WEST SUSSEX COUNTY COUNCIL CONSULTATION

TO:	Arun District Council FAO: Claire Potts
FROM:	WSSC Highways - Public Rights of Way
DATE:	2 March 2022
LOCATION:	Barnham, Eastergate, Westergate BEW Parcel SC1 Barnham
SUBJECT:	BN/11/22/OUT Outline application with all matters reserved (except for the A29 Realignment) for the demolition of existing structures and mixed use development to provide residential dwellings (Use Class C3), Care Home/Senior Living Accommodation (Use Class E/F2/Sui Generis), a Primary School plus open space, landscaping, drainage and all other associated ancillary works; and realignment of the A29 and early connection to existing A29 including construction of a new road carriageway, junctions and associated infrastructure. This application also lies within the parish of Aldingbourne, affects the setting of listed buildings, affects the character & appearance of the Eastergate Church Lane Conservation Area and affects a Public Right of Way. This application is the subject of an Environmental Statement.

DATE OF SITE VISIT:	n/a
RELEVANT PUBLIC RIGHTS OF WAY NUMBER(S):	FP296, FP321, FP323
RECOMMENDATION:	No Objection (With Conditions)
S106 CONTRIBUTION TOTAL:	n/a

Figure 4.2: Indicative Access and Movement Parameters Plan (by JTP)

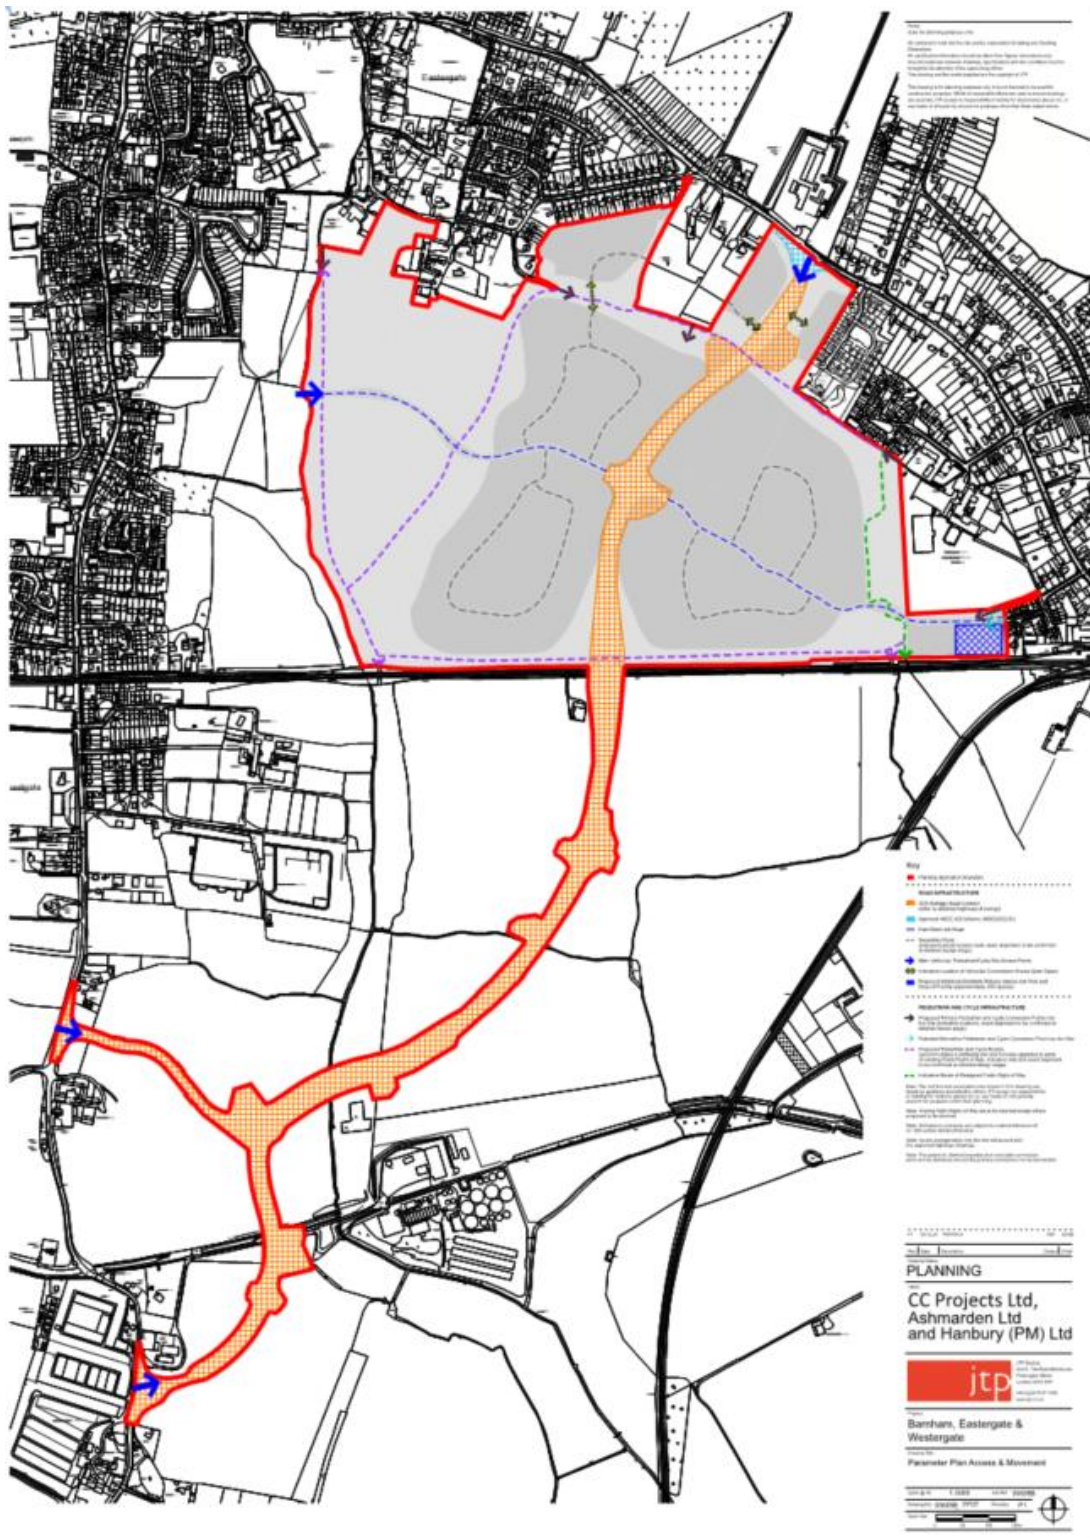
FP321 is not always recognised as an existing PRow, purely as a proposed, segregated, pedestrian / cycle route on many diagrams. I note it is not being diverted but is being changed from a footpath to a pedestrian and cycle route whilst on site as part of the 'green link'. As footpaths do not allow cyclists, **please confirm whether your intention is to upgrade the PRow to a Bridleway or confer permissive cycle rights**. A Bridleway is preferred as this will give permanent rights.

With regards to it being segregated (page 24 of the DAS, extract of page 48 of Connectivity Principles from the Framework Masterplan Document), please note that **a Public Right of Way cannot be segregated. The full width must be available to all users**. This width must be a minimum of 3m and surfacing constructed to an approved standard.

I note FP323 will cross the East-West link road. It is described within section 7.4 Sustainable Movement of the DAS as a pedestrian and cycle crossing of the East-West Link Road.

As footpaths do not allow cycle use, is the intention to upgrade the PRow from a footpath to a permissive cycleway or Bridleway? Again, Bridleway status is preferred to secure user rights.

The surface we will require of this diverted PRow will depend on its status. **Please advise on planned width of this path.**
